From: [REDACTED]
Sent: 10 January 2018 21:36
To: Planning.Responses
Cc: Deborah Urquhart
Subject: Highways Response A/155/17/OUT

SUBJECT: A/155/17/OUT- Outline application with some matters reserved for 3 No. dwellings. This application may affect the setting of a Listed building & is a Departure from the Development Plan.

Avenals Barn, Water Lane, Angmering, West Sussex, BN16 4EP

Date: July 2017 Scales: As shown Paper size: A1 Dwg No: AR-122-01-A

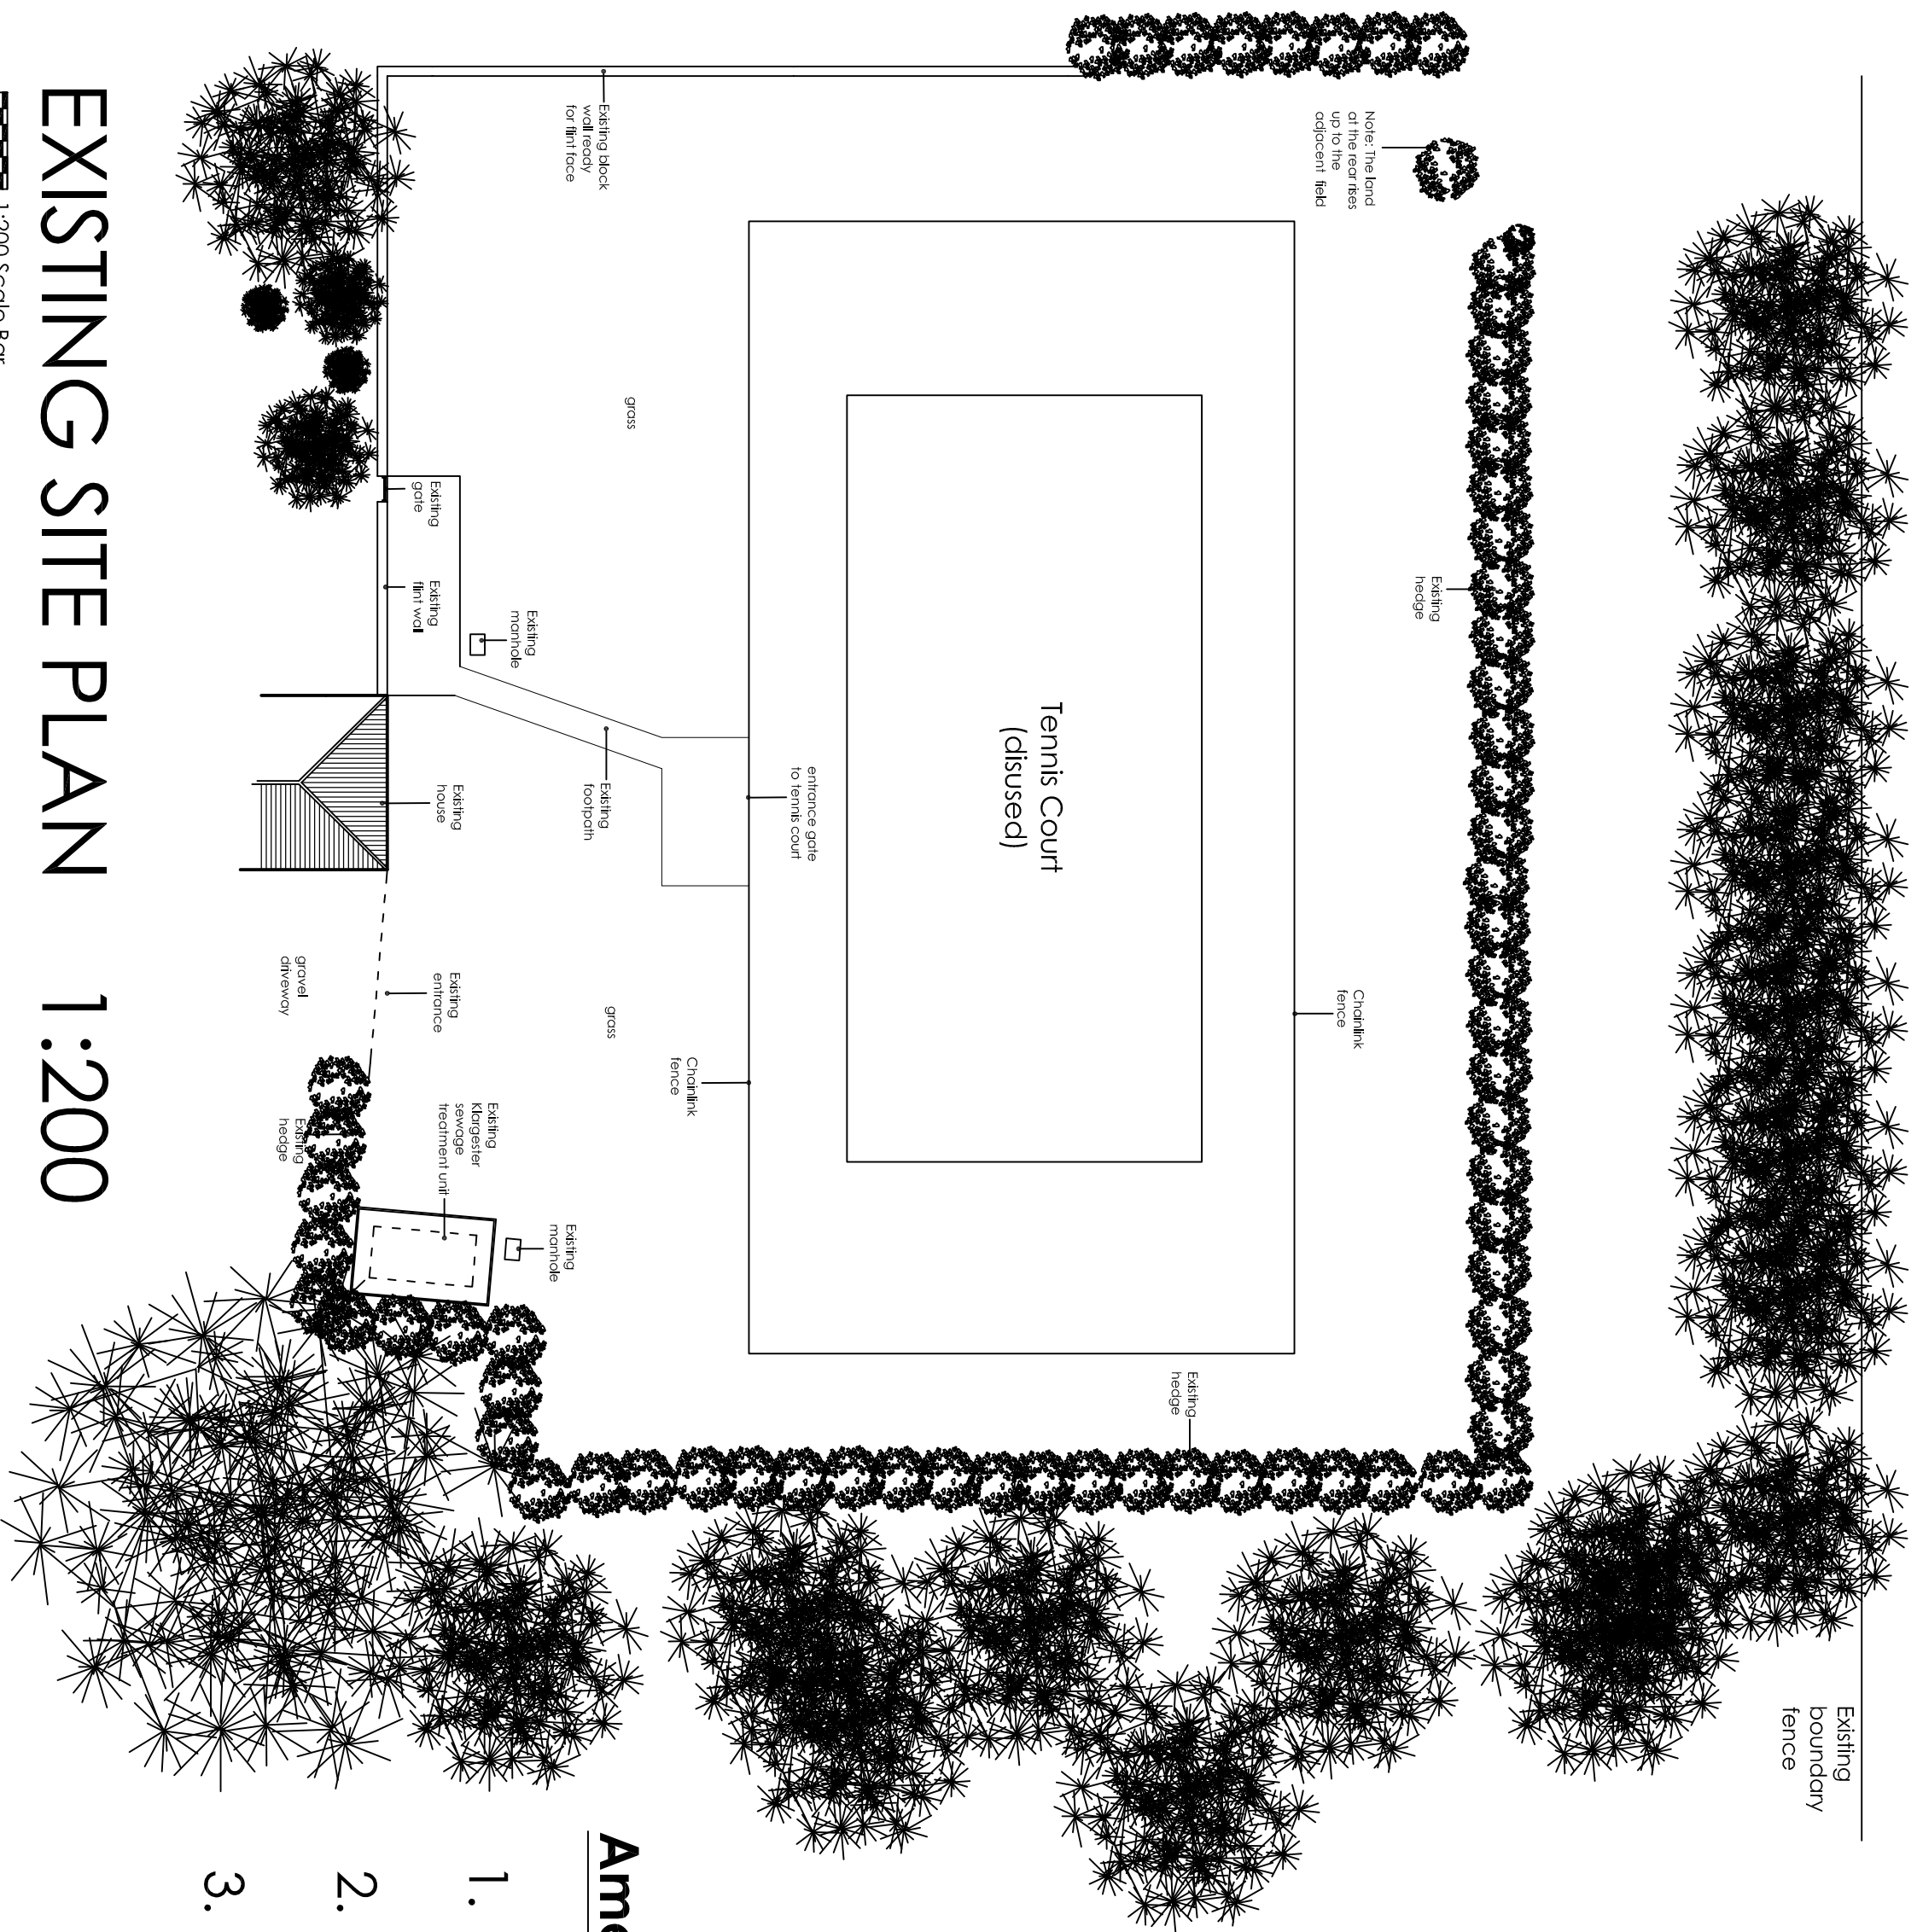
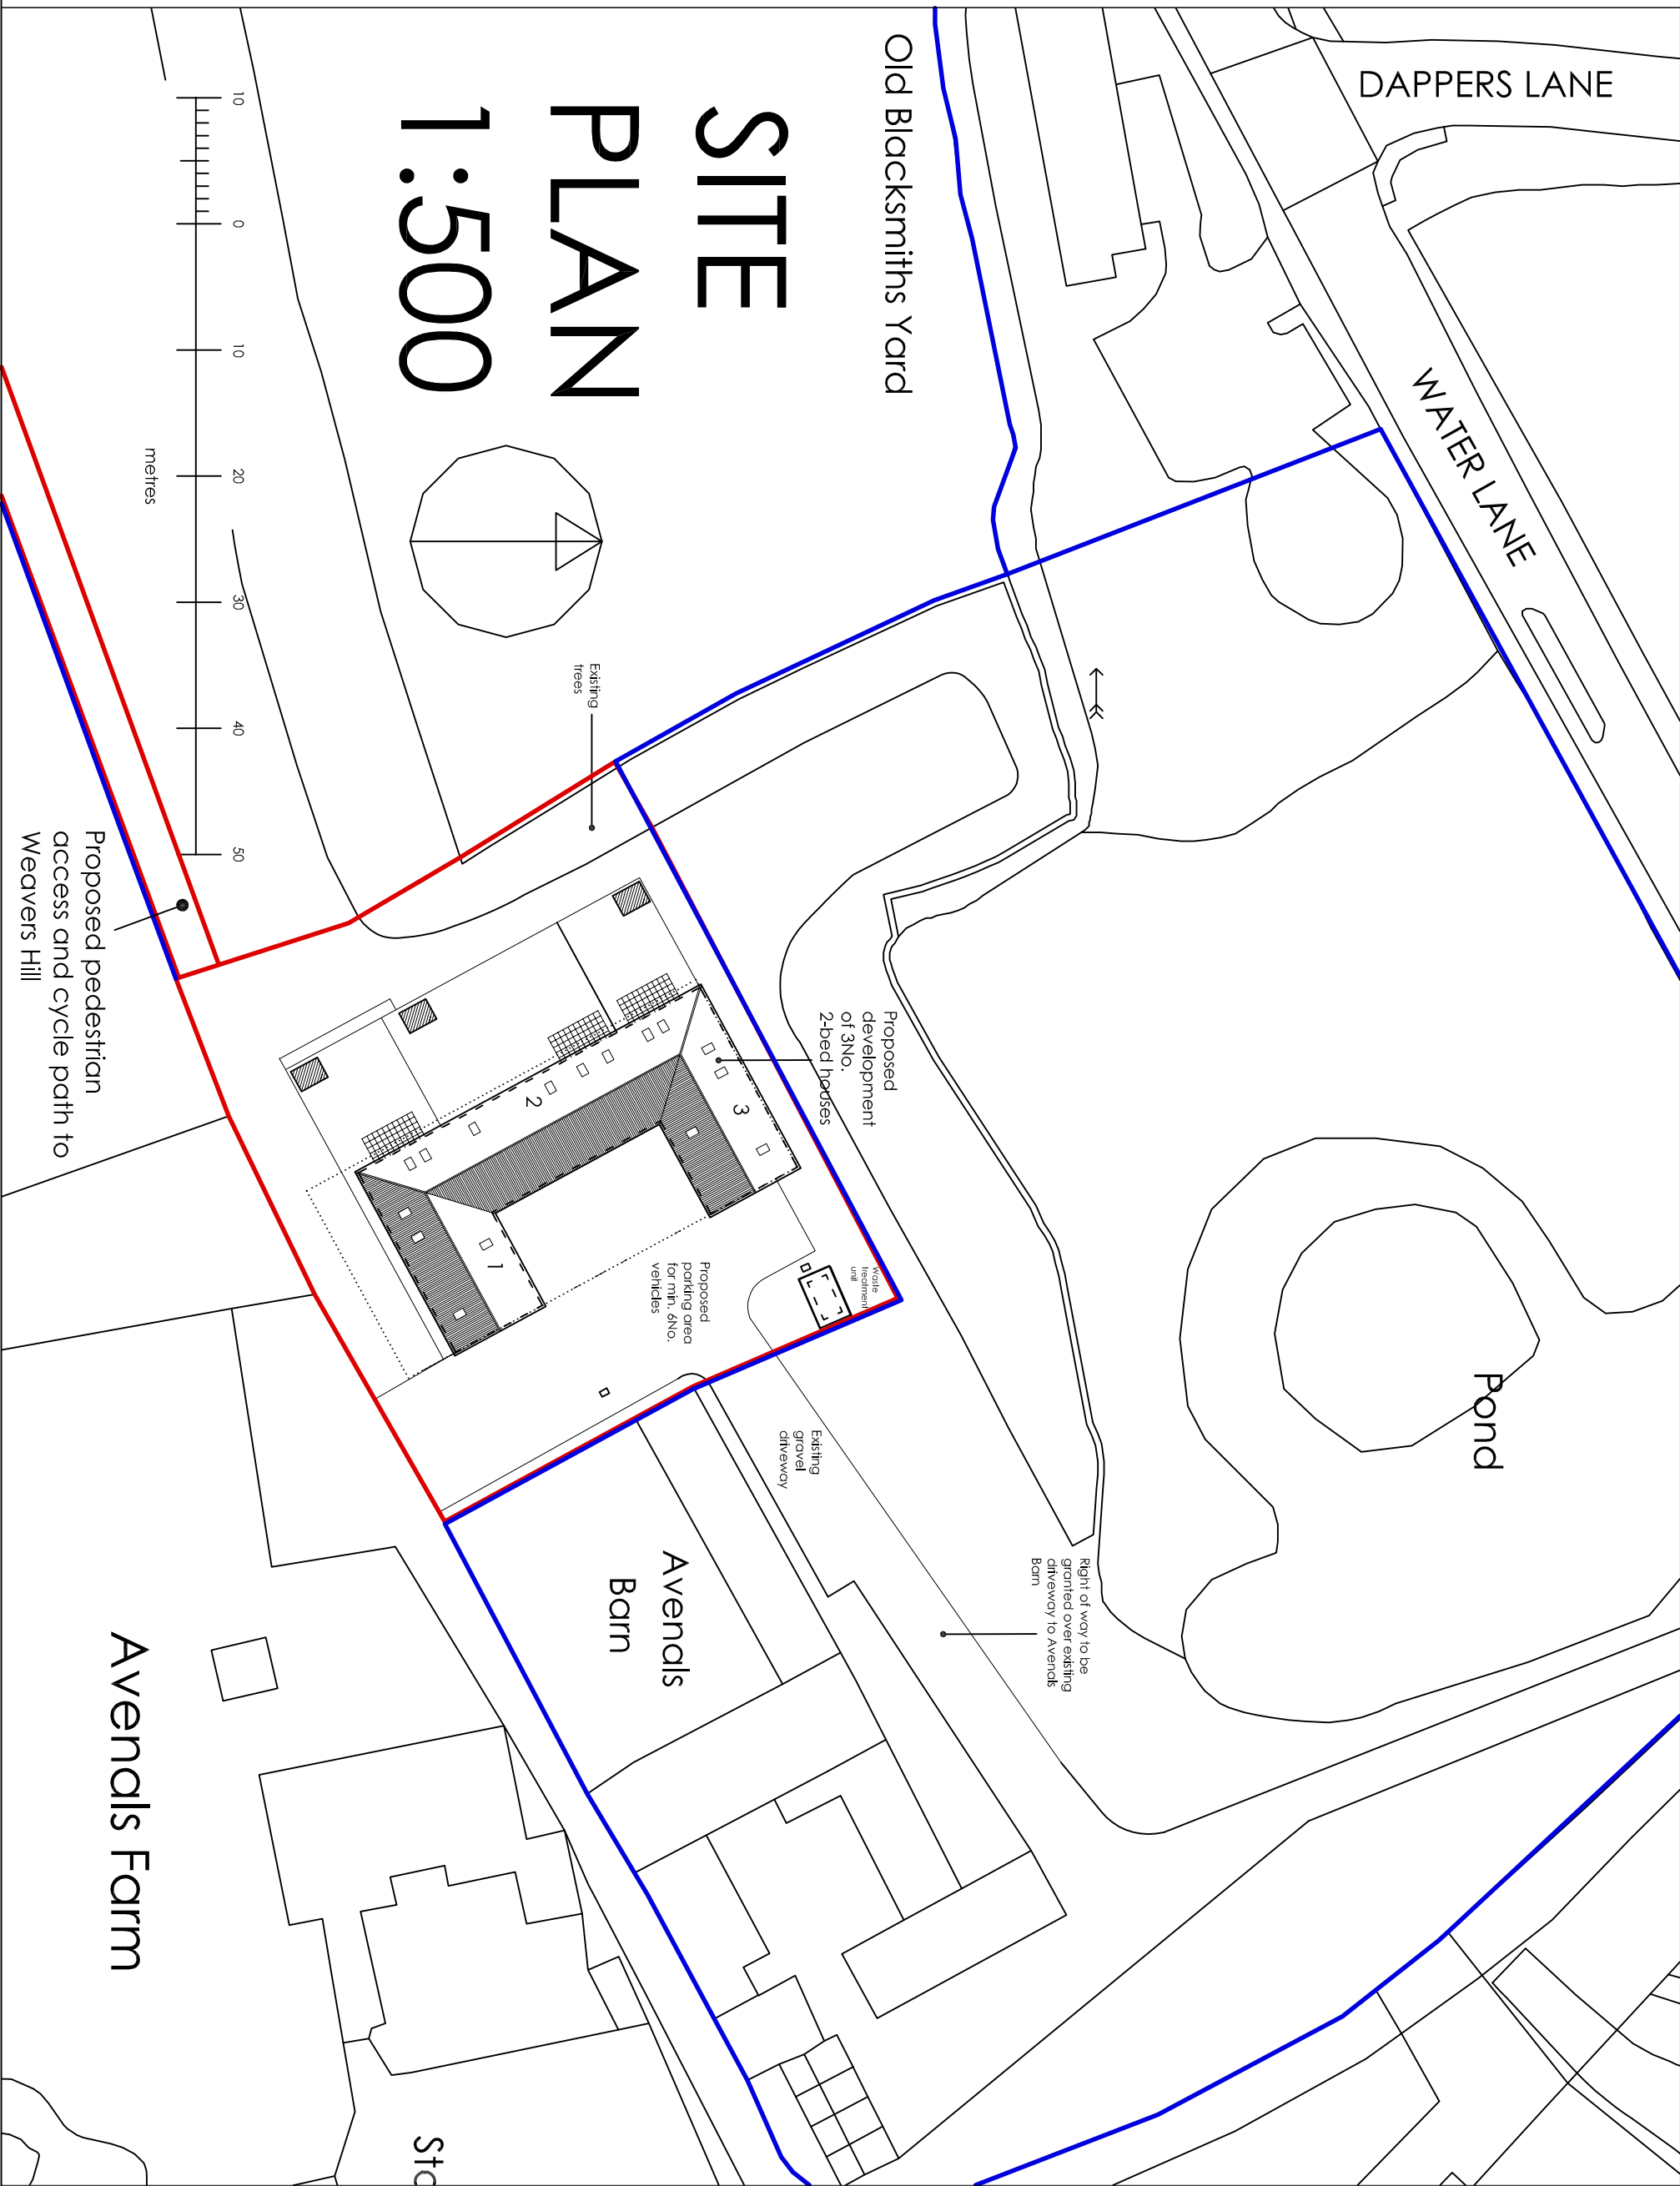
The amended plans outline that there is a proposed formalised pedestrian access linking Avenals Farm with Weavers Hill. Weavers Hill is not served along its length with pedestrian footways however it is street lit at the junction to Cumberland Road which also provides footways for pedestrians.

The proposed pedestrian access would benefit from being integrated with the existing footway network which is present on the opposite side of Weavers Hill at the junction with Cumberland Road; this would provide a more fluid link with the existing network. However the Local Highway Authority (LHA) is required to consider the size of the development proposed and potential use of the pedestrian access which is anticipated to be infrequent as the link would be only be required for residents of Avenals Farm.

Although the proposed footway does emerge at a point that does not link with the existing network, it is considered that the bus stop present 5m south of this location currently operates on a similar arrangement and upon checking Sussex Police Collision data, has operated safely for some time.

The LHA advises that any pedestrian access is built to a minimum of 1.5m in width. This measurement is in line with the guidance set out within The Department for Transport's Inclusive Mobility documentation. This states that 1.5m is sufficient for a wheelchair user and an ambulant person to walk side by side. This pedestrian access is advised to be surfaced with a bound material to prevent any overspill being dragged into the carriageway at Weavers Hill.

It is presumed by the LHA that the pedestrian access is to remain within private ownership and be maintained accordingly.
